RESPONSE TO SUBMISSIONS REPORT

Intercontinental Hotel
Alterations and Additions
Modification
(SSD-7693-Mod 2)

Prepared for
MULPHA
19 April 2022

SITE PLAN
 TITLE
 JOB NO 6680
 DWG NO 1001
 ISSUE A

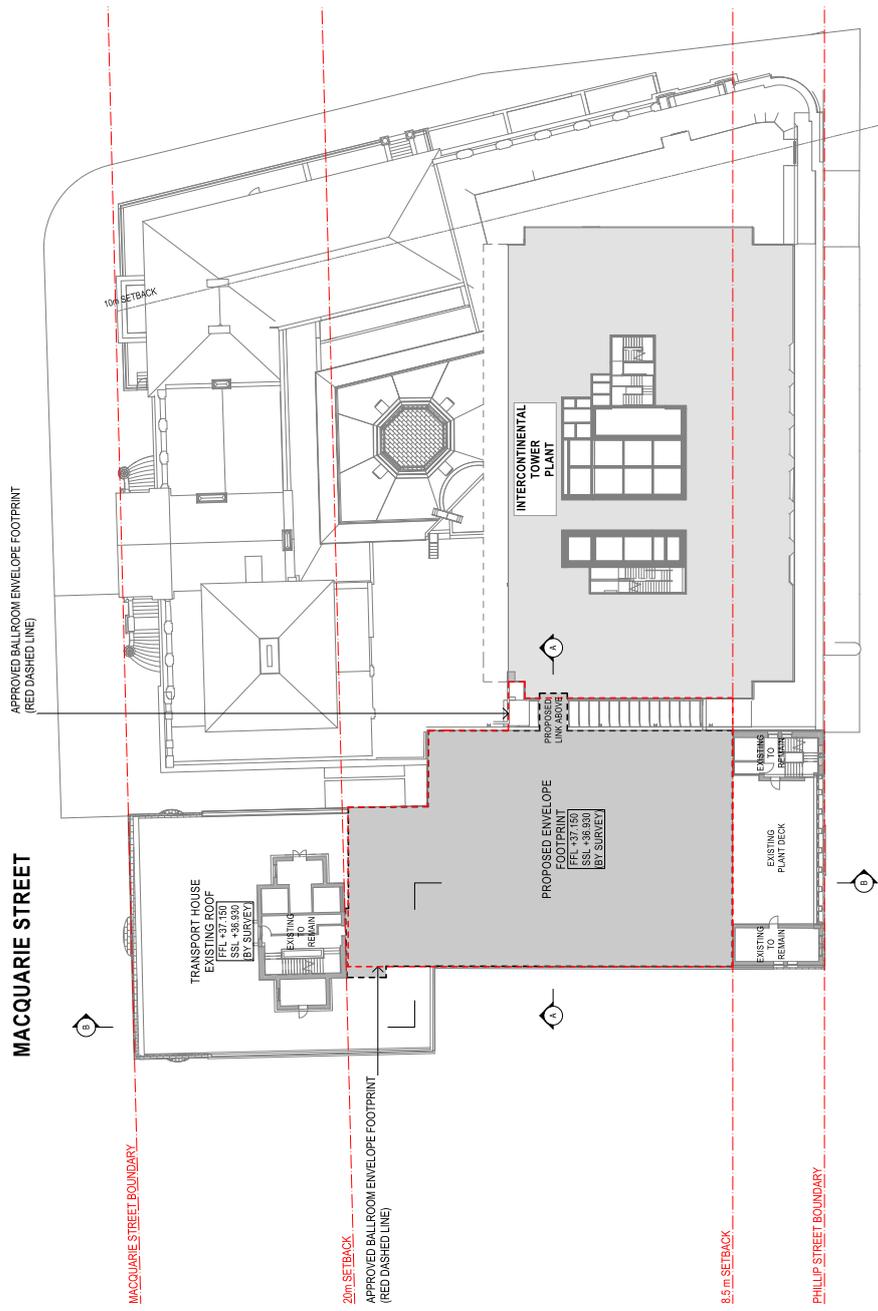
<p>Corridor link to hotel</p> <p>It is unclear from the submitted HIS and Visual Impact Assessment (VIA) if due consideration has been given to the temporary function centre corridor link to the hotel and associated heritage or visual impacts.</p> <p>The Modification Application seeks to remove the requirement for a Competitive Design Process for the</p>	<p>Refer to Urbis Heritage response at Appendix C. Copied verbatim below for completeness:</p> <p><i>The corridor link is substantially set back from the Macquarie Street frontage. It is not likely that the link would be visible at all from the public domain east of the subject site. Even if the link was visible, it would exist in the context of existing, significantly larger development on the site and would be so set back from Macquarie Street that there is no</i></p>	<p>Appendix C</p>

PROPOSED ADDITIONAL STAGE 1-A ENVELOPE: SECTION A

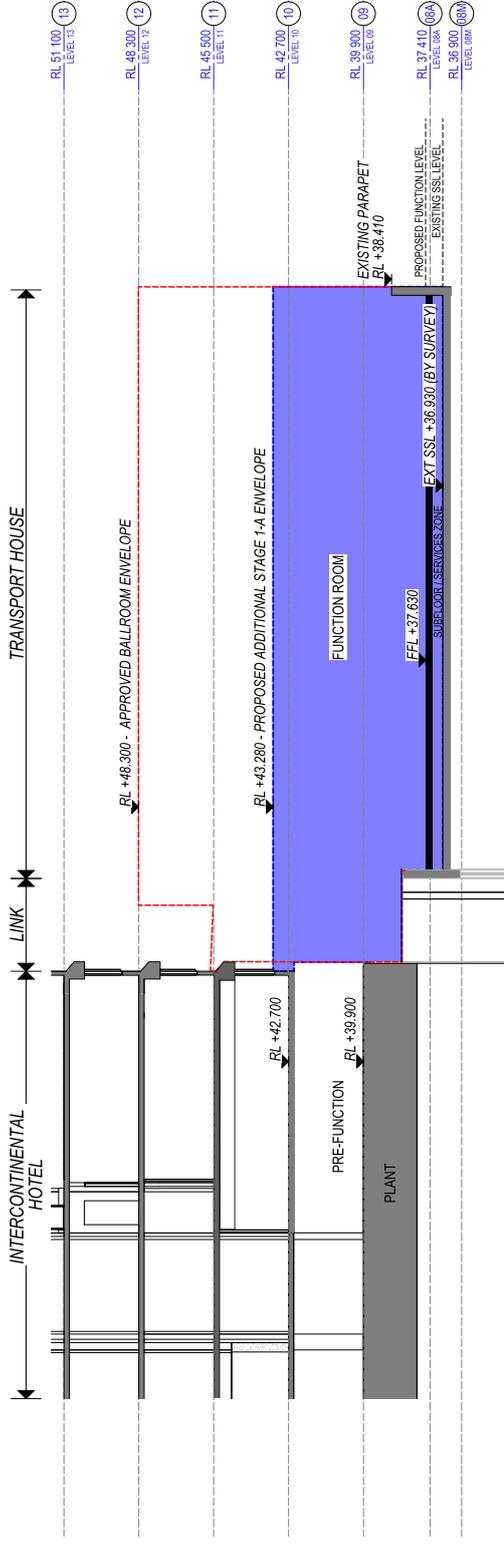
<p>Heritage NSW</p>		
<p>The proposed deck, balustrade etc. were not part of the previous approval. The works are within the 20m setback imposed by the Independent Planning Commission and so may be in contravention of the previous approval. These works will have an adverse heritage impact in terms of view, setting and integrity.</p> <p>There is likelihood of further impact of associated works probable to follow, such as shade structures, lighting, seating, roof top landscaping, etc. In view of the above, the proposed deck is not supported. The drawings do not indicate the setback of the glass balustrade from the existing parapet which needs to be clear.</p>	<p>Refer to Urbis Heritage response at Appendix C. Copied verbatim below for completeness:</p> <p><i>"This application seeks only consent for the inclusion of a stage in SSD – 7693 and a building envelope. Physical works do not form part of this application. The Heritage Impact Statement prepared as part of the application therefore discusses the type of works that would be facilitated by the Stage 1a application. Details of the setback of the glass balustrade or any other required ancillary structure are not finalised at this stage and consent is not sought for these elements. The plans provided with this response establish that the glass balustrade is to be approximately 2.9m set back from the façade however these details are to be determined via a separate detailed SSDA process. It is not anticipated that there will be any fixed structures on the deck, the detailed SSDA design stage will determine the most appropriate</i></p>	<p>Appendix C</p>

Summary of Issue Raised	Response	Appendix
	<p><i>location/design of any such elements with regard for heritage and visual impacts.</i></p> <p><i>This separate SSDA process will provide HNSW with an opportunity to comment on this detailed application which will include a comprehensive design package and a revised visual impact assessment which represents the final design of the proposed works (including the setbacks, materiality and form). The team is further able to commit to consultation with HNSW regarding setbacks and ancillary structures prior to the submission of the detailed SSDA.”</i></p>	
<p>The proposal describes the addition as a single storey even though the proposed height is 6.35m. It should be clarified whether the proposed envelope will comprise one or two floors.</p>	<p>Refer to Urbis Heritage response at Appendix C. Copied verbatim below for completeness:</p> <p><i>“The physical addition does not form part of this application. The intention is that the proposed building envelope facilitates a single storey space, with a heightened ceiling appropriate to its use as a function space.</i></p> <p><i>Notwithstanding the number of internal floors the HIS prepared by Urbis and the Visual Impact Assessment prepared by AE Design Studio addresses the proposed presentation of the scale and finds that it is much more diminutive than what has been previously approved as a Stage 1 envelope, and has been carefully designed in terms of scale and siting to respond sympathetically to the existing building form of Transport House.</i></p>	Appendix C
